From: Maria Tomalova
Sent: 19 January 2022 15:51
To: [REDACTED]
Subject: PO/16/21/DOC

Peckhams Poling Street Poling BN18 9PT

Approval of details reserved by condition imposed under ref PO/8/21/L relating to Condition No 2 - details of wood treatment and new windows and doors

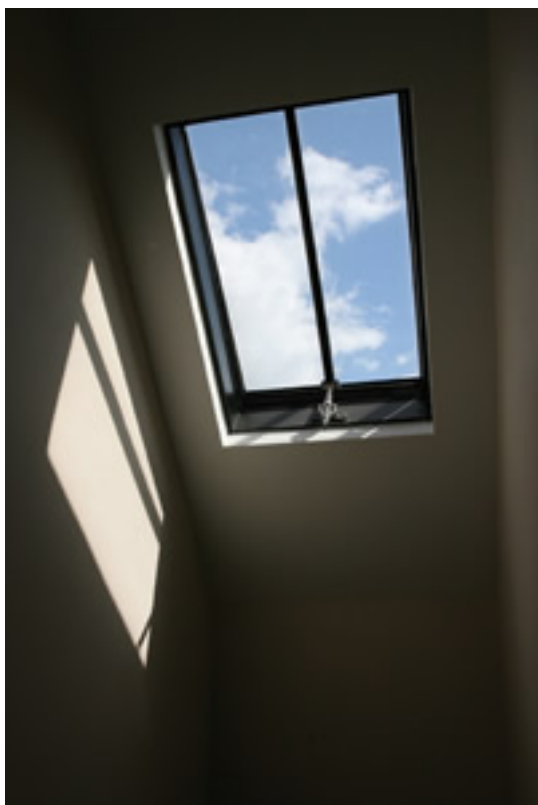
The proposed rooflights seem to be acceptable. However, the level of information regarding the windows is limited to two photographs. It would help to have sections of the sliding doors – which were not clearly displayed on the approved consent.
